OAKLANDS FARM SOLAR PARK

The Applicant's Comments on Responses by Interested Parties to the Third Written Questions and other Submissions made at Deadline 6 December 2024

Document Ref: EN010122/D7/15.4

Figure 1c: Habitat constraints plan

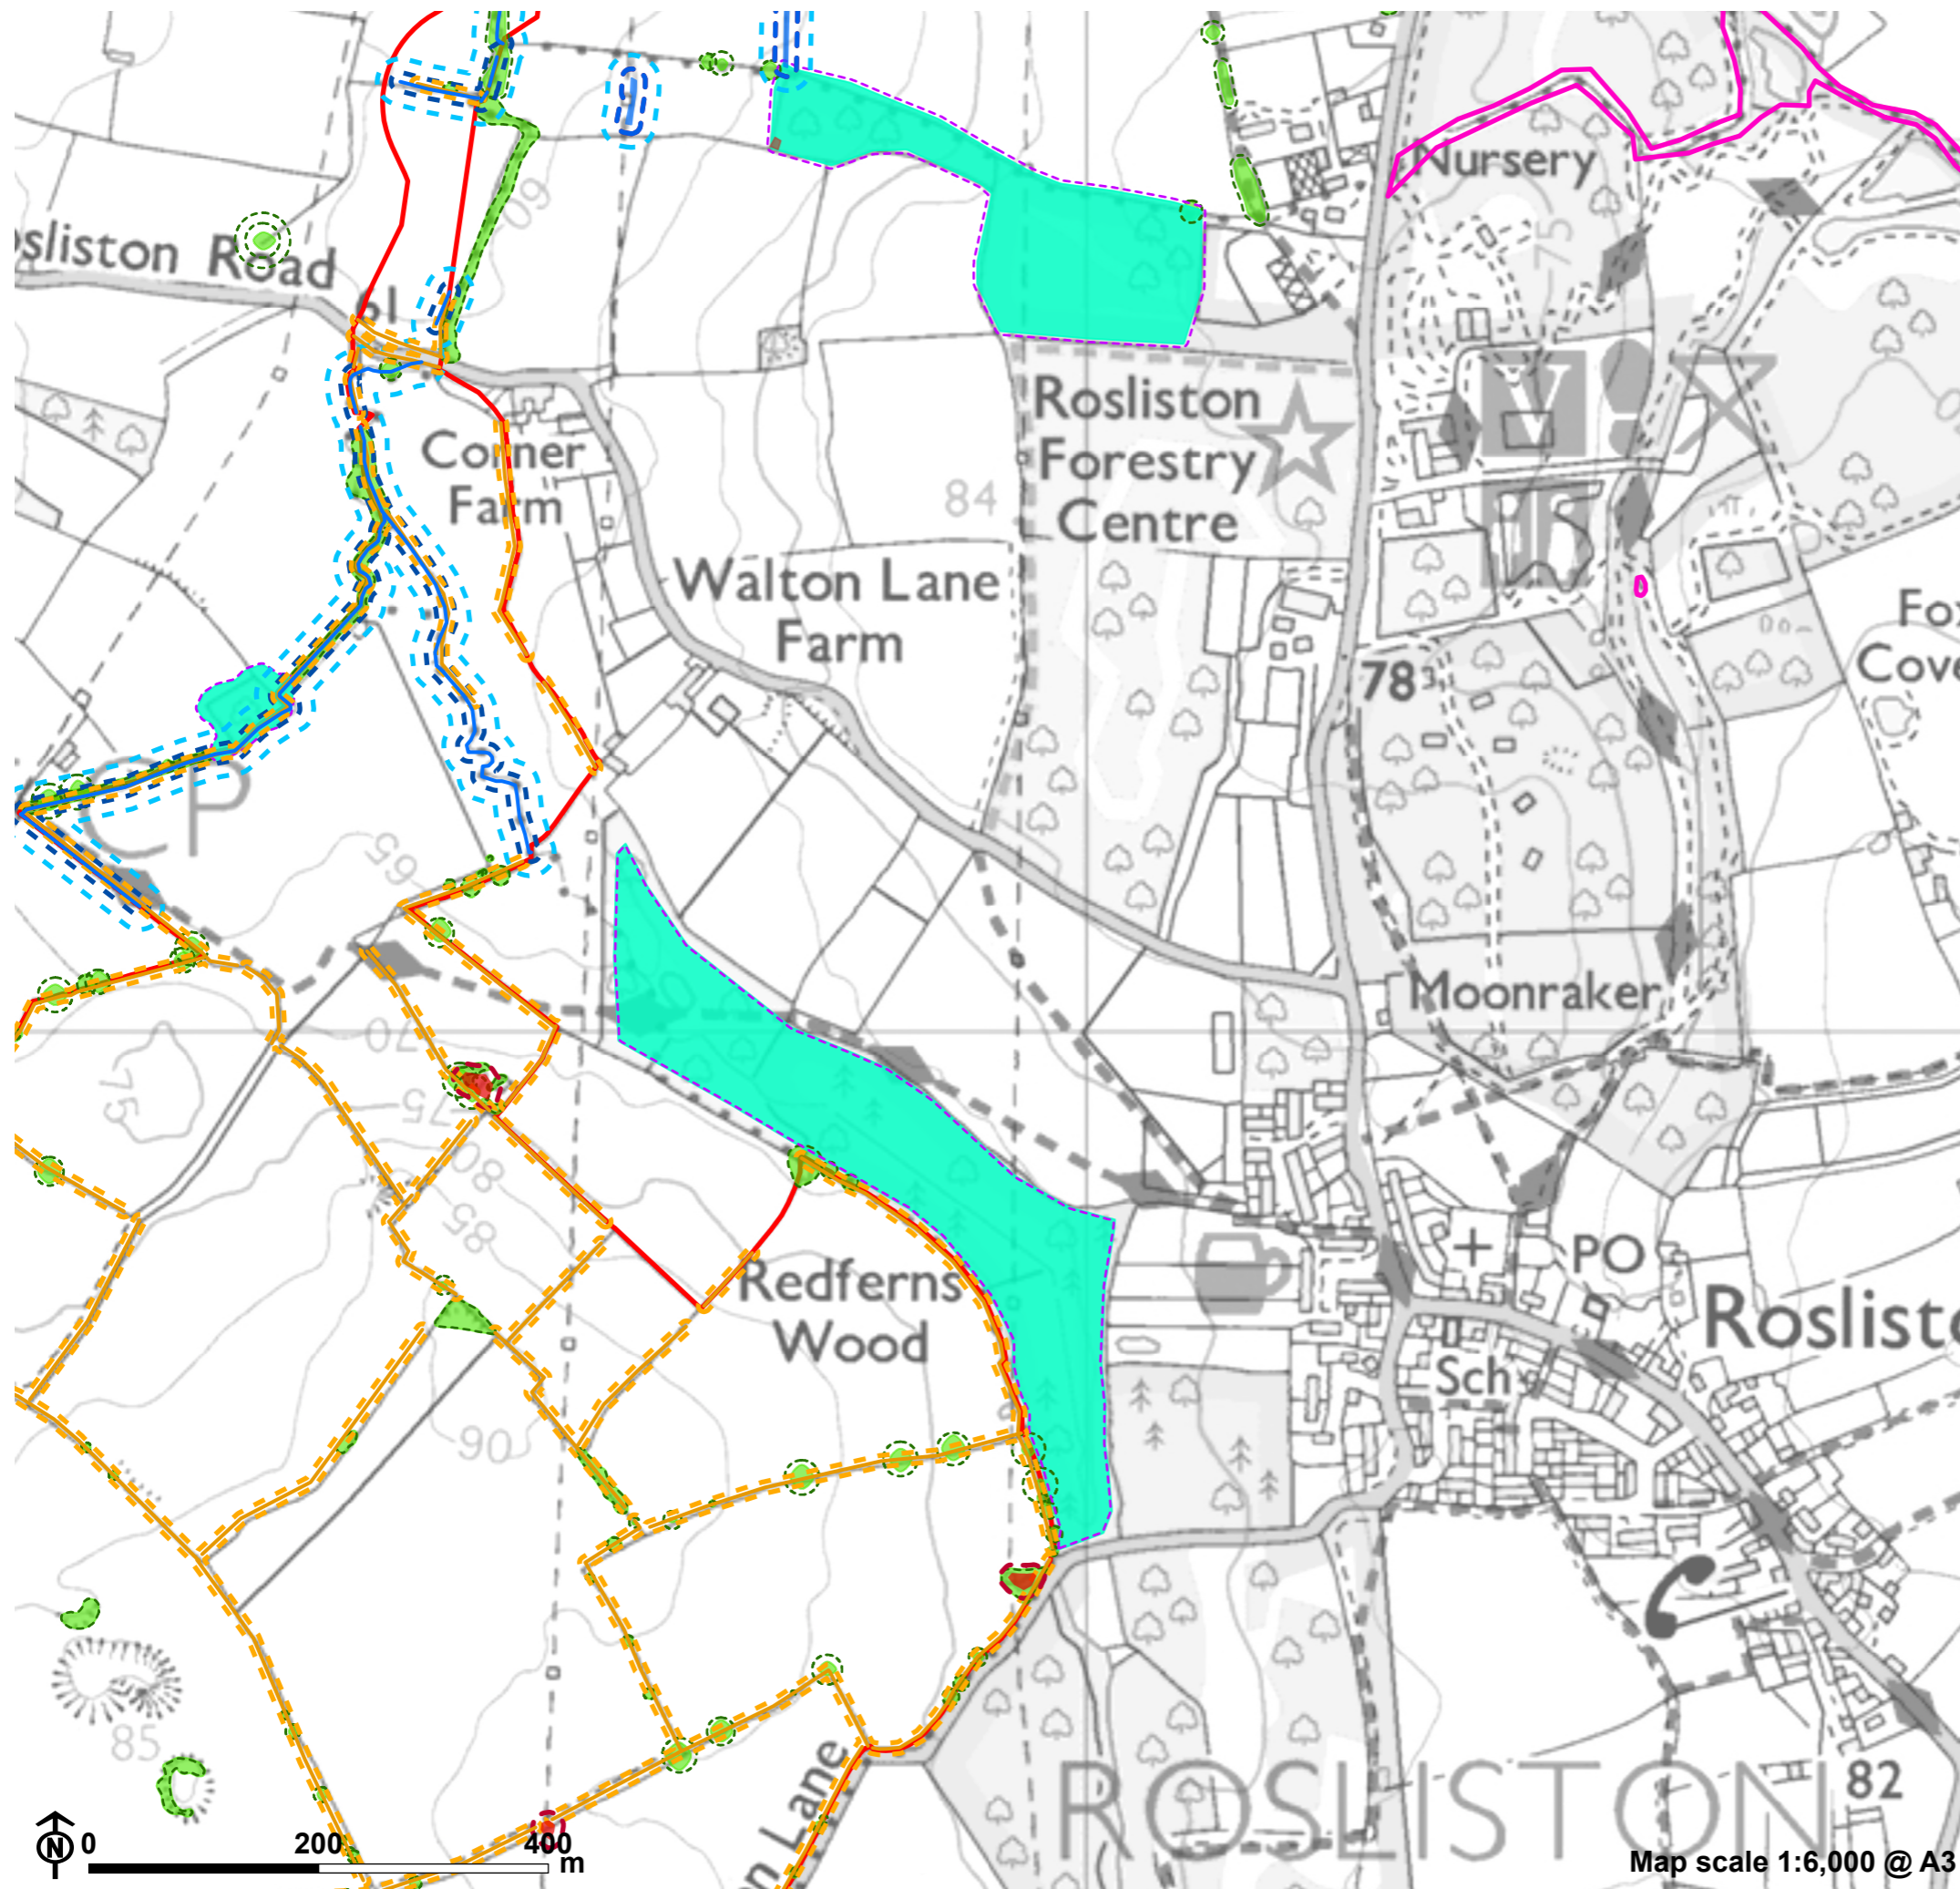
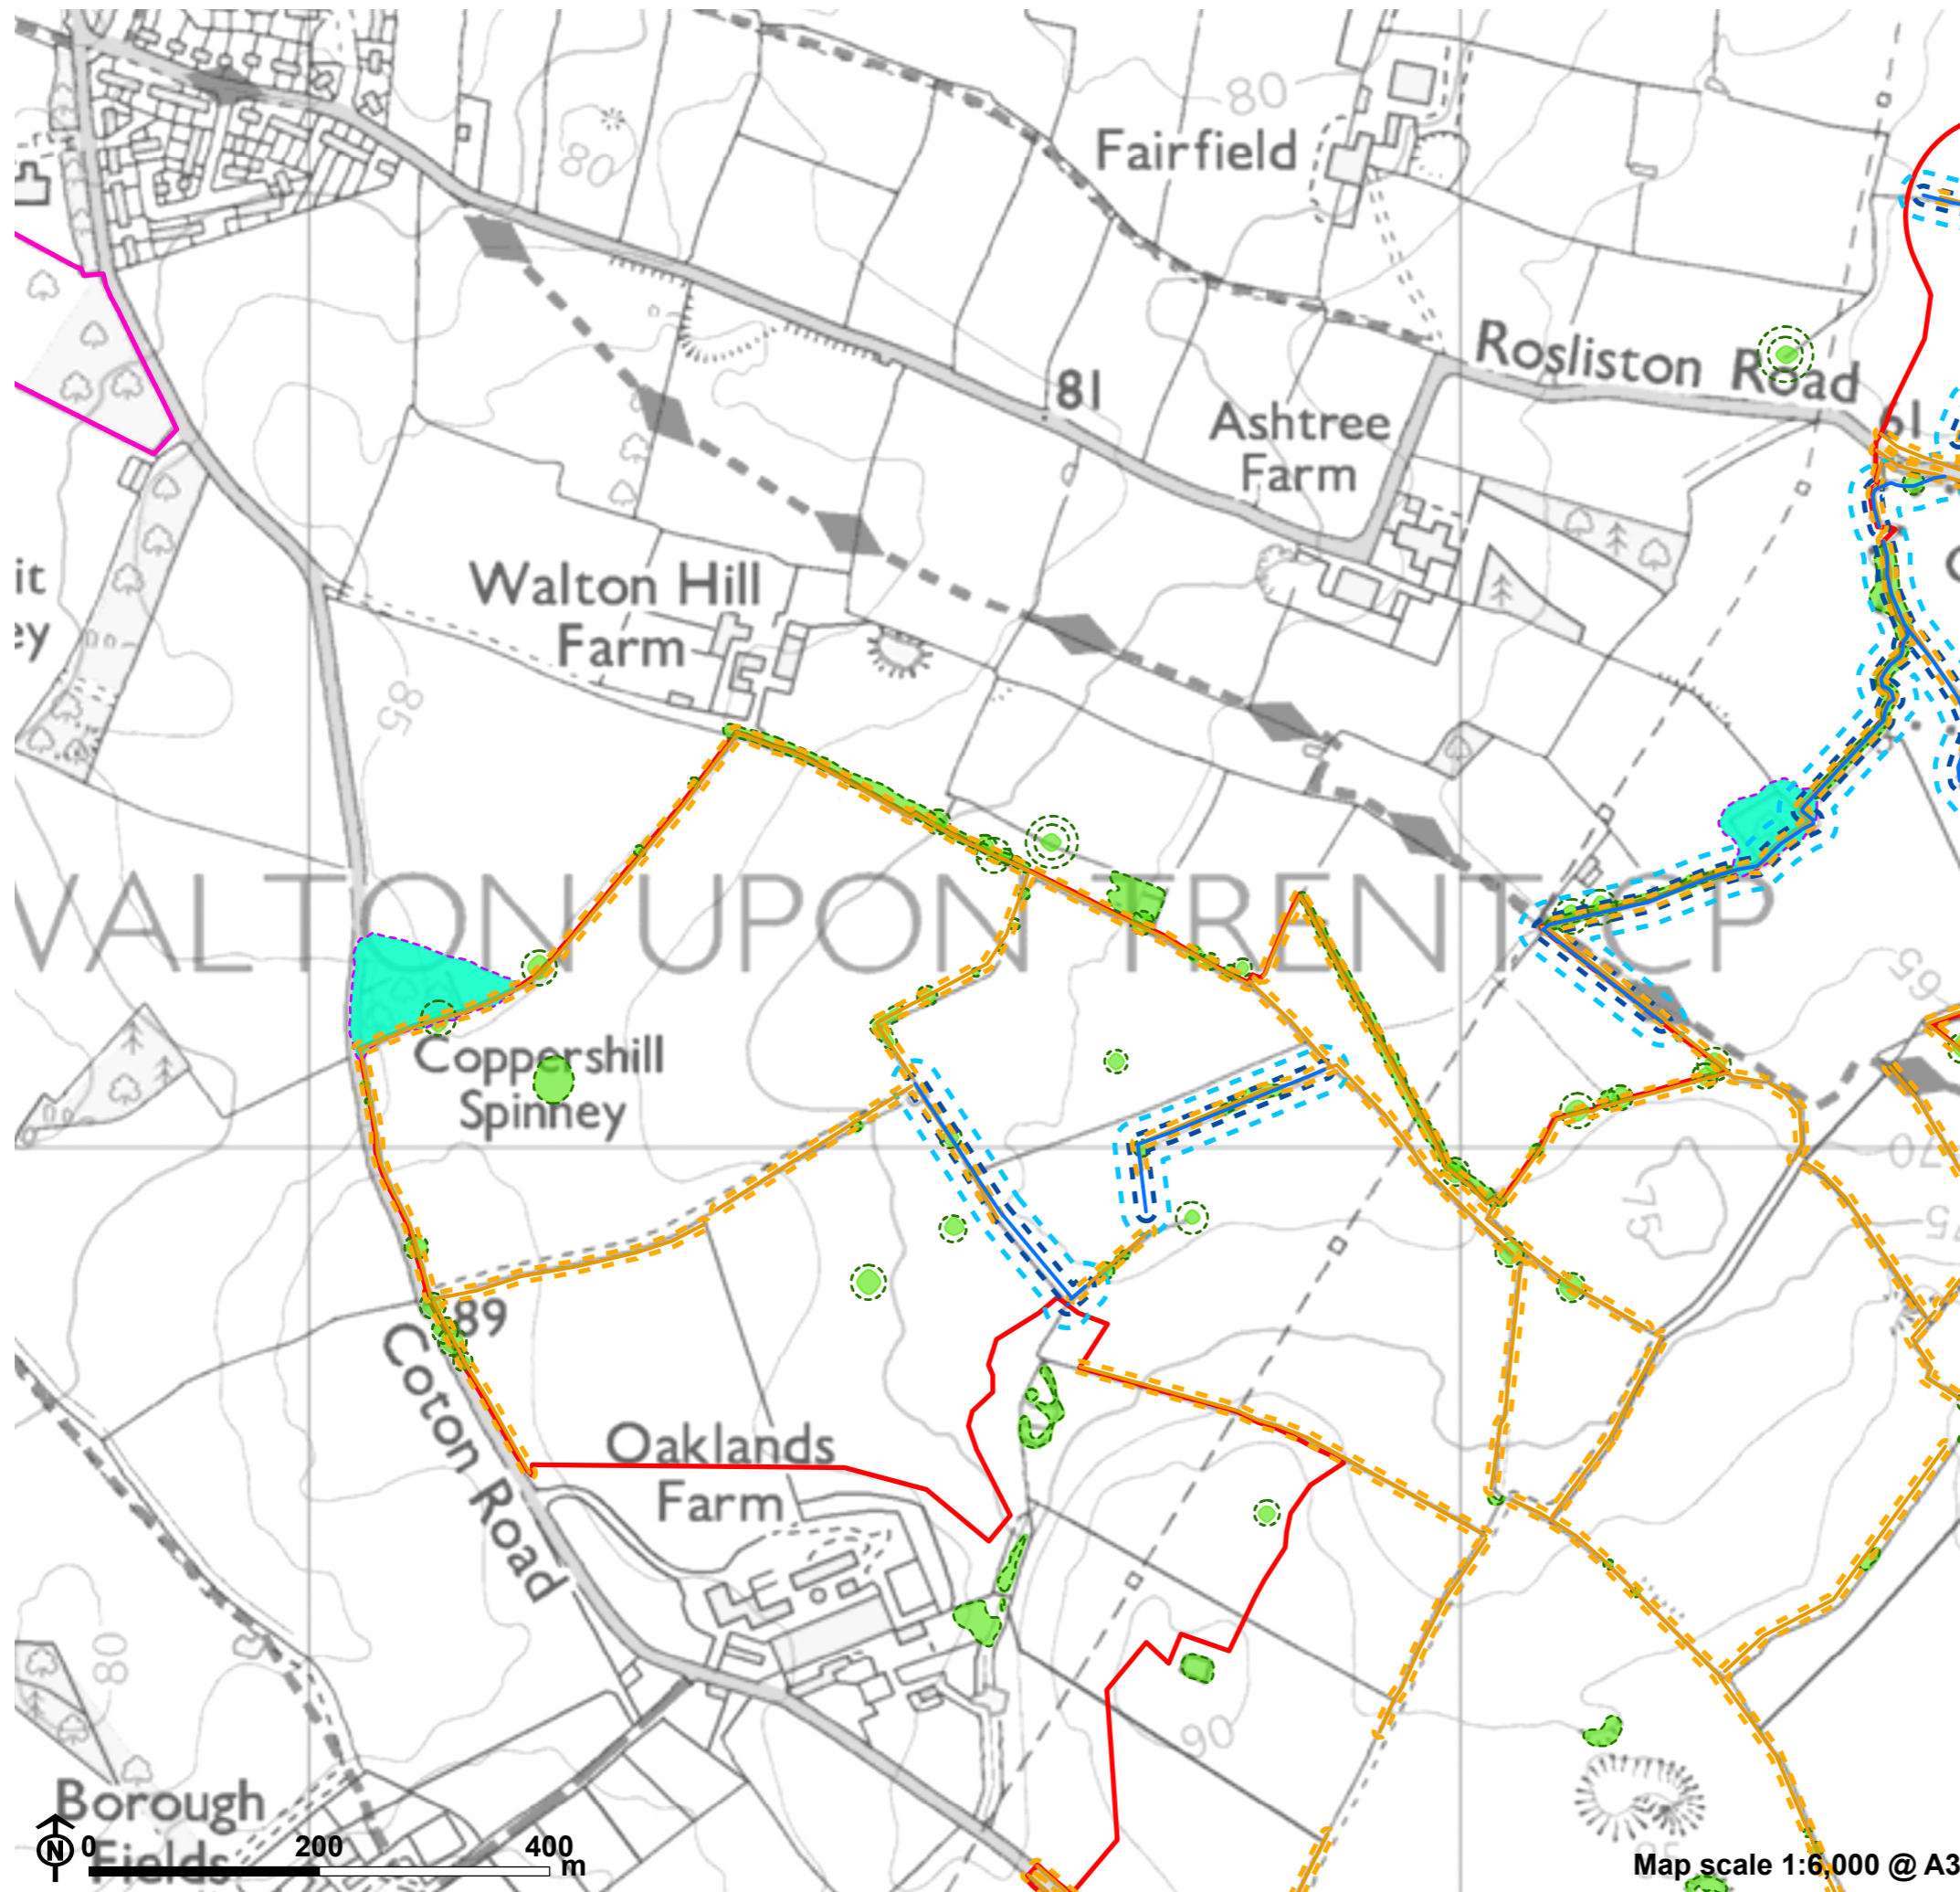
7.3	Applicant, SDDC, DCC			
	<p>Habitat Constraints Plan</p> <p>SDDC [REP4-014] and DCC [REP4-012] referred to the need for a Habitat Constraints Plan with interpretable maps to provide the necessary details and extent of site clearance works relating to buffer zones to sensitive features such as ancient/ veteran trees, other retained trees, ponds, watercourses, hedgerows and woodlands.</p> <p>The Outline CEMP [REP5-011] includes provisions for a Habitats Constraint Plan [Section 2.8.5] and buffers [Sections 2.6.4, 2.6.5, 2.8.2, 2.8.3, 2.8.5, and 2.8.6]. The Applicant provides a series of interpretable maps of habitat constraints [REP5-030].</p> <p>a) Please could the Applicant add the draft interpretable maps to the Outline CEMP [REP5-011] and secure that interpretable maps be included in the final CEMP?</p> <p>b) Please could SDDC and DCC comment?</p> <p>c) Please could SDDC and DCC also summarise any outstanding concerns at Deadlines 7 and 8 with suggestions about how they might be addressed?</p>

Applicant at D6	SDDC at D6	DCC at D6	Applicant at D7
	<p>a) The draft Habitat Constraints Plans have been added to the Outline CEMP at Appendix 4. A final version of the Habitat Constraints Plans will be delivered as part of the final CEMP as secured by Requirement 9(2)(n).</p> <p>b) No response required.</p> <p>c) No response required.</p>	<p>b) SDDC have reviewed those interpretable maps and they provide useful clarity and should be attached to the Outline CEMP for further comprehensive review.</p>	<p>DCC welcomes the inclusion of the habitats constraints plans referenced in the OCMP at 2.8.5 including buffer zones, and requirement 9 for approval of the LPA prior to construction.</p>	<p>The Applicant welcomes the comments from both SDDC and DCC confirming acceptance of the draft Habitat Constraints Plans. No further action is required.</p>
